Subject: Fwd: Planning application 2021/91239 amended plans comments

Subject: Planning application 2021/91239 amended plans comments

We see amended plans dated 17/6/21 were uploaded onto the Portal overnight on 23/6/21 so first available for public viewing on Thursday 24/6/21

Proposed Site Layout Plan

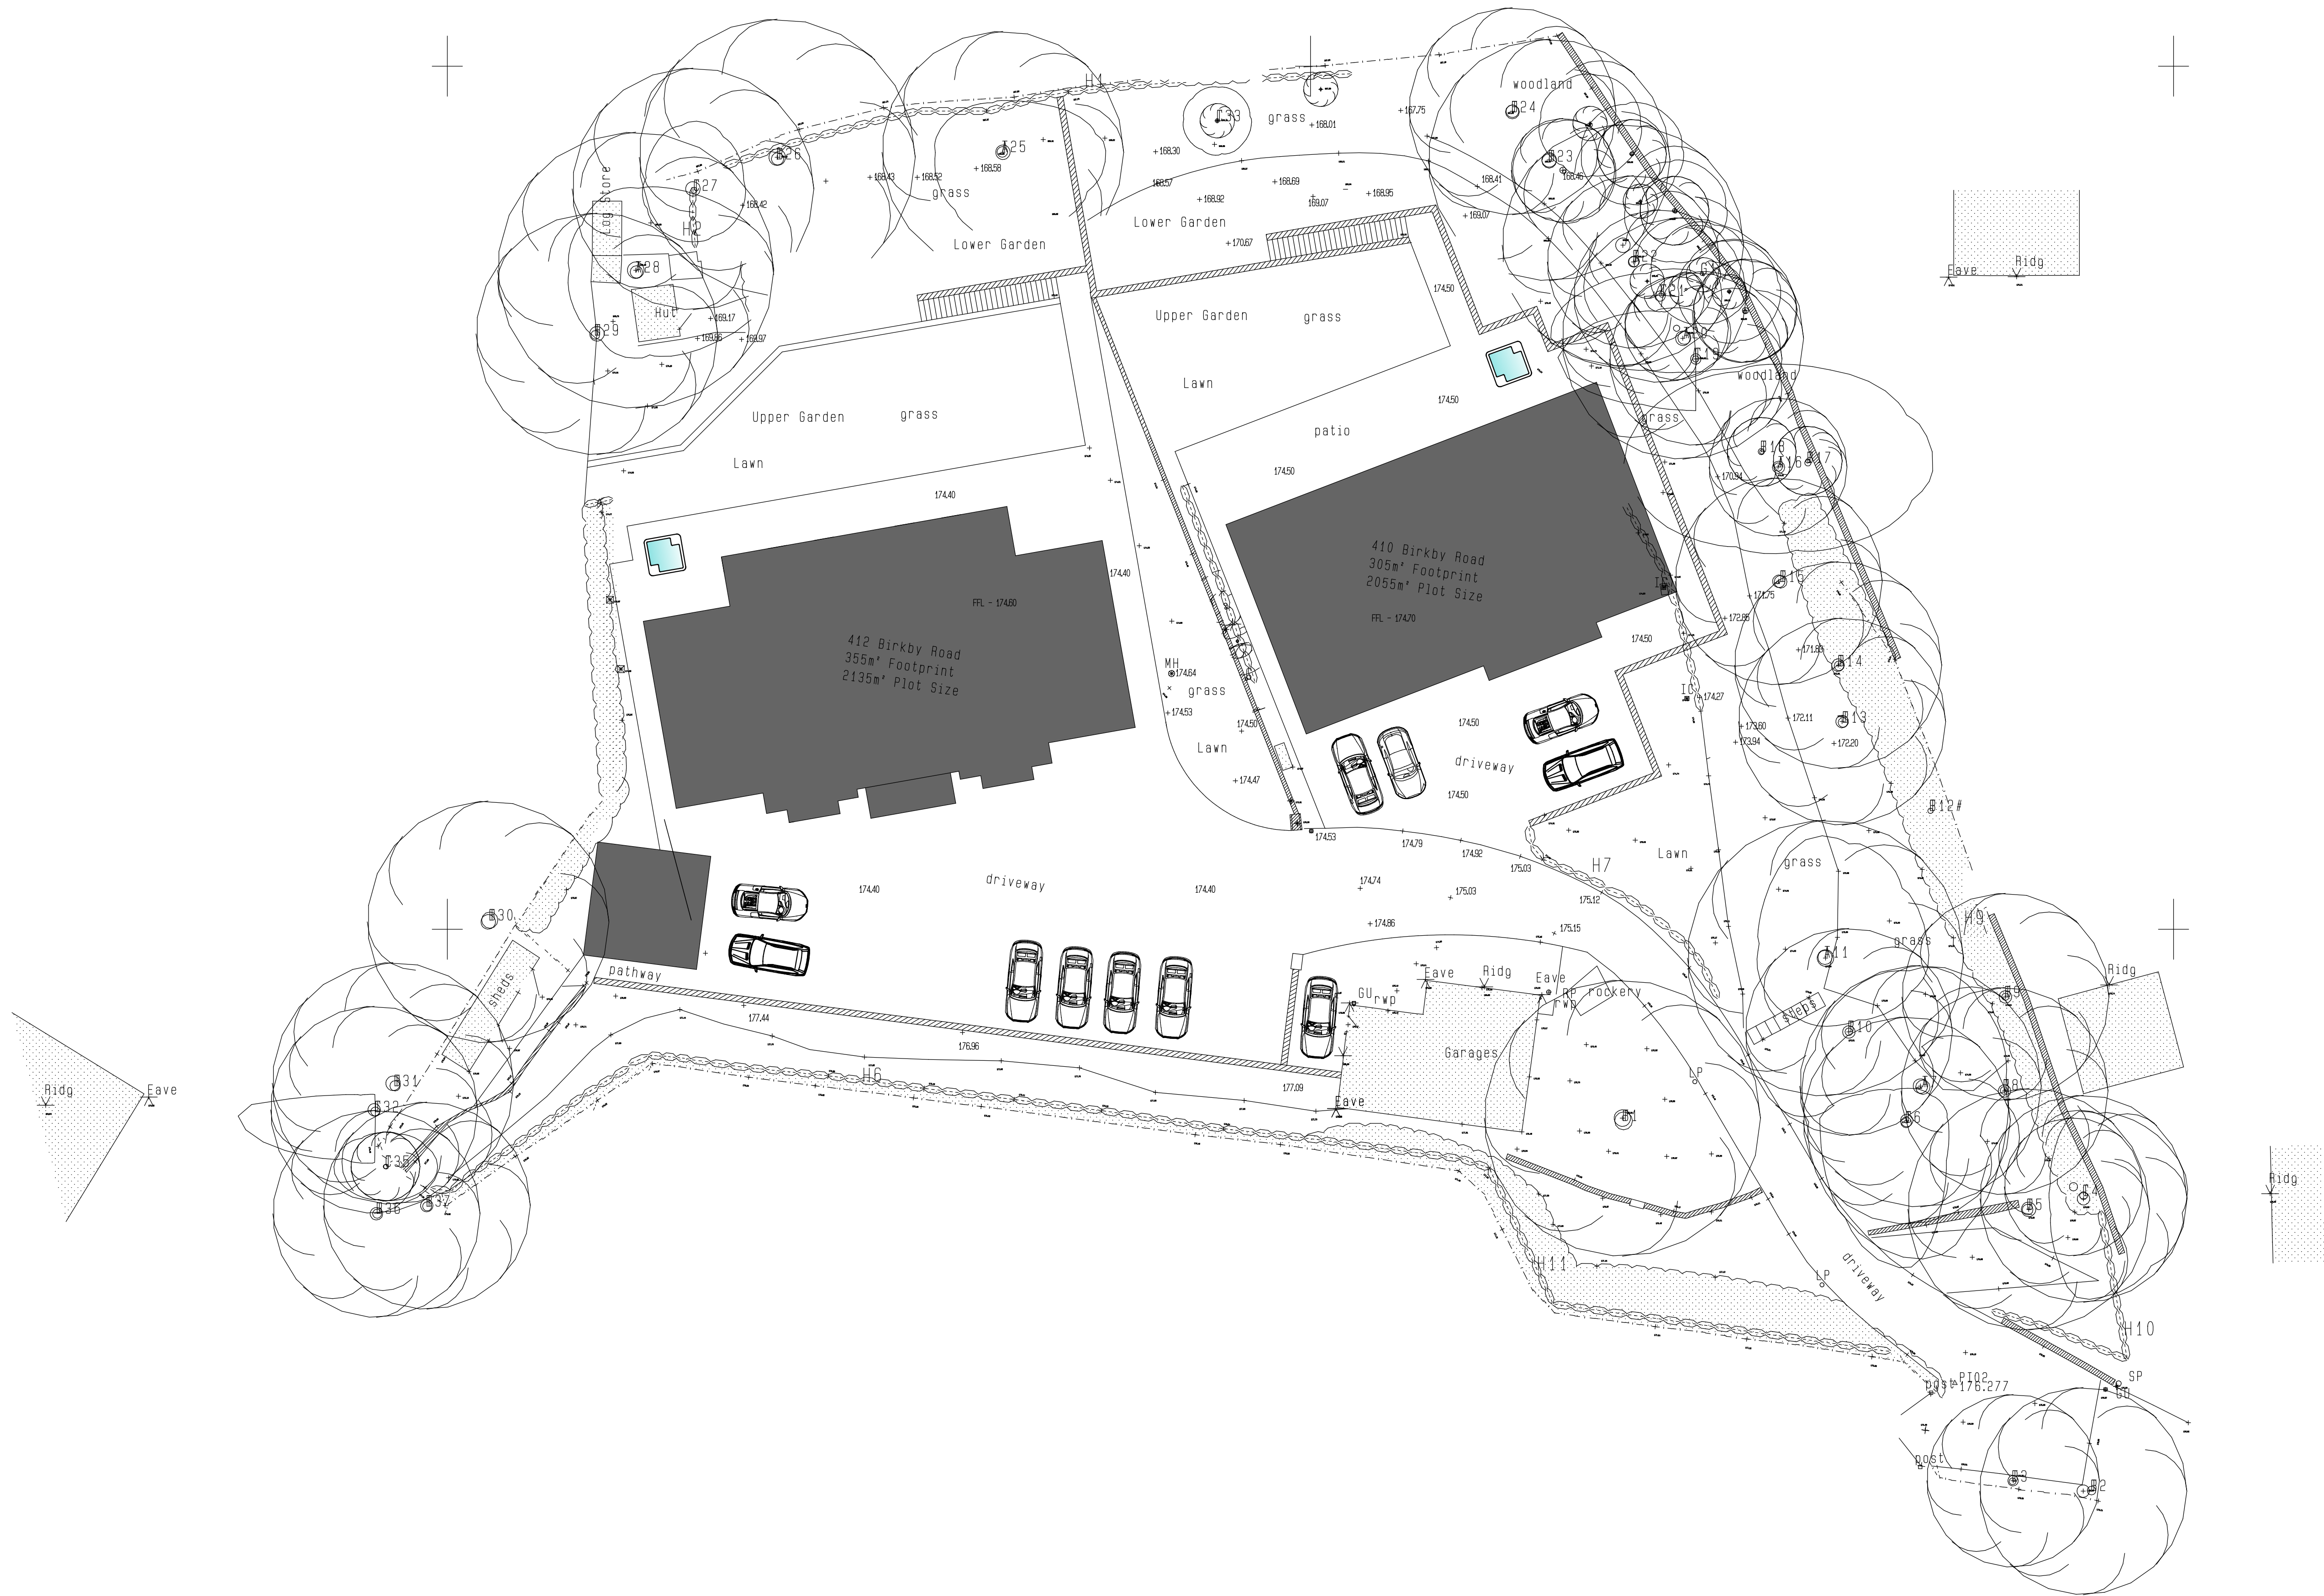
Previous concerns from multiple commenters regarding the number of parking spaces remain the same. The garage for 412 may have changed position but the application form still states increasing parking spaces to 15 even if less cars are now shown diagrammatically on the amended plan. There is already garaging for 7 cars for the two properties . Why the need for 15 parking spaces as well ? That level of traffic is not appropriate on a single lane private drive that is a maximum of 70 yards from the extremely busy crossroads of Birkby and Halifax roads. Queues already regularly form on Birkby road up to the traffic lights with Halifax road. If multiple cars are waiting to exit

the private drive then anyone wanting to enter the drive won't be able to- causing further hold ups and backing up both ways on Birkby road . The proposed Kirklees Highways department changes to this major junction are to improve traffic flow. So parts of planning applications that could have an effect on these junction changes must be seriously considered.

It's not clear how far the retaining wall for 410 would encroach into the protected woodland and if pile driving will still be required . If the house building line is directly up to the red hatched protected woodland area, referred to frequently in previous objections, then the retaining wall presumably encroaches. It shouldn't be allowed to encroach at all, as per the Councils very own specific planning conditions applied to the original property just over 7 years ago.

Side Elevation

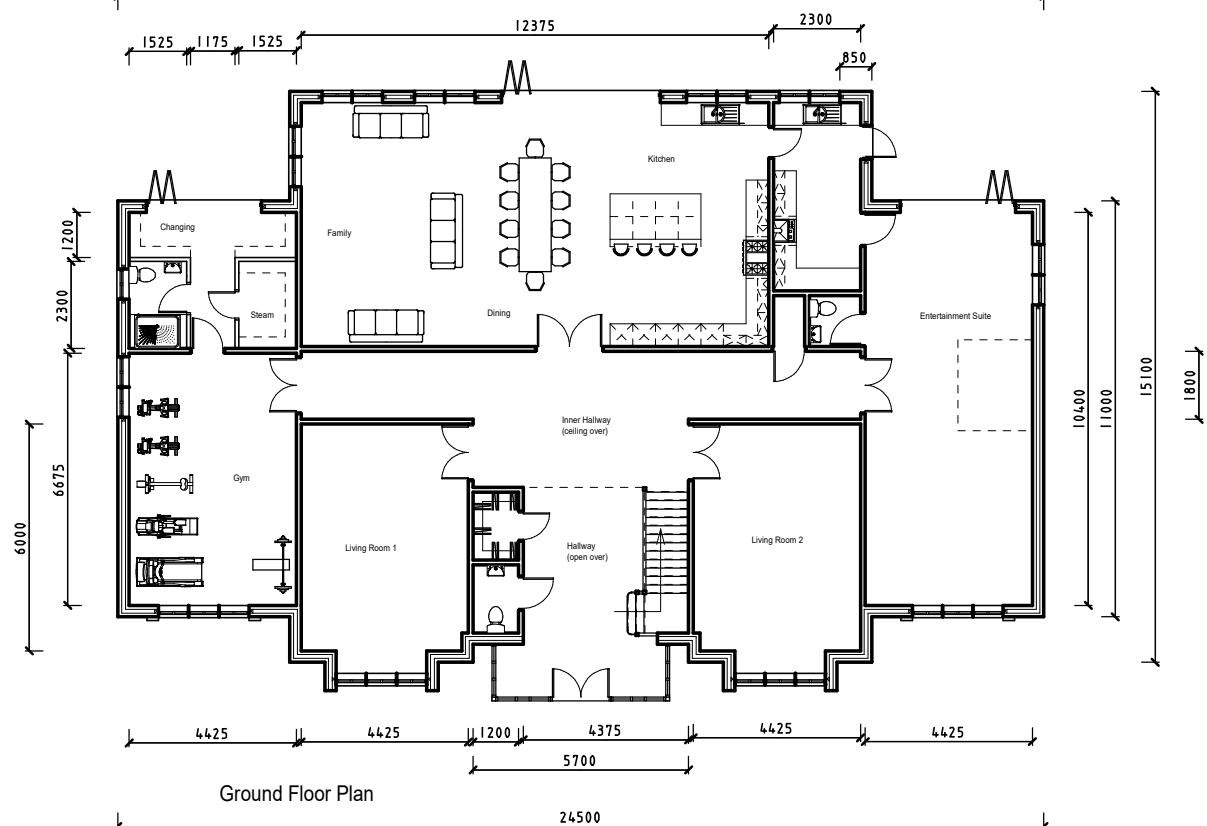
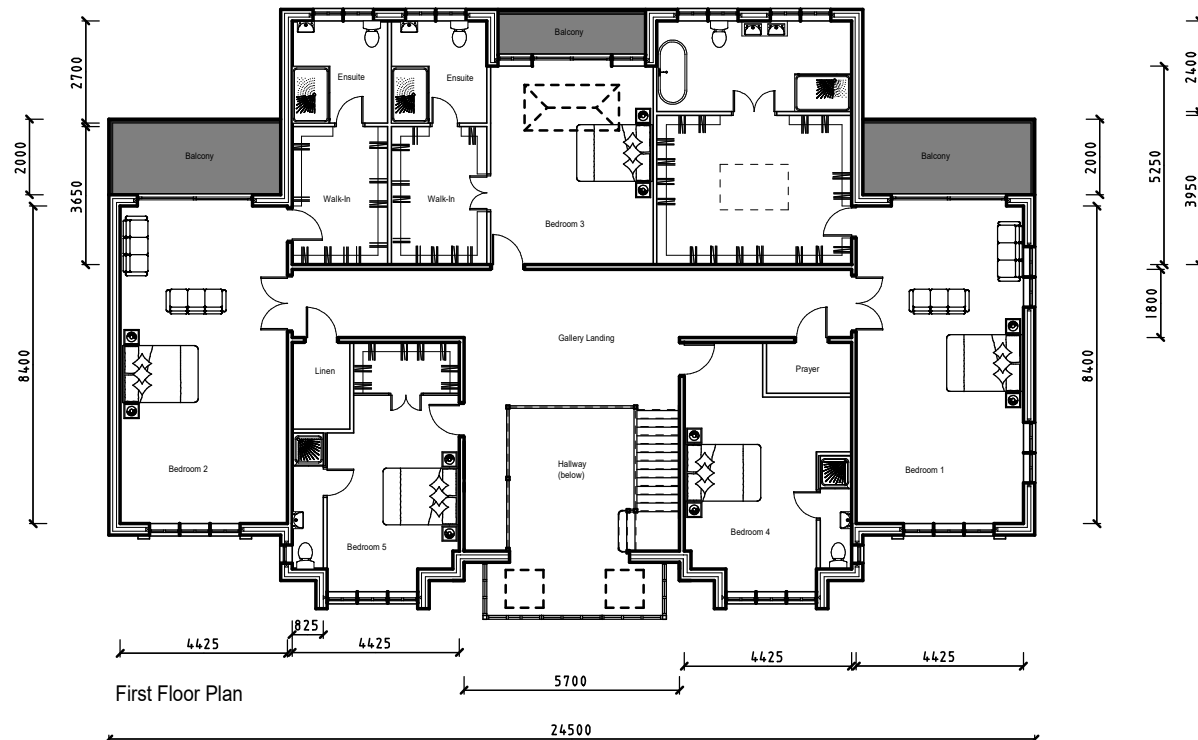
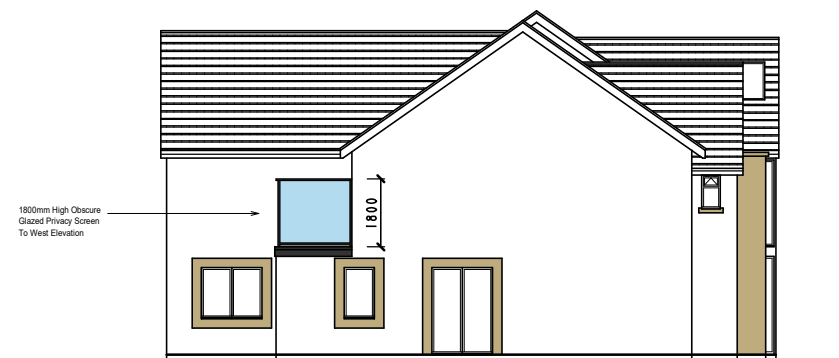
Just one window has been removed from the eastern wall of 410 in the amended plan So it still doesn't comply with the councils specific condition just over 7 years ago stating no additional windows to what is in the current bungalow.
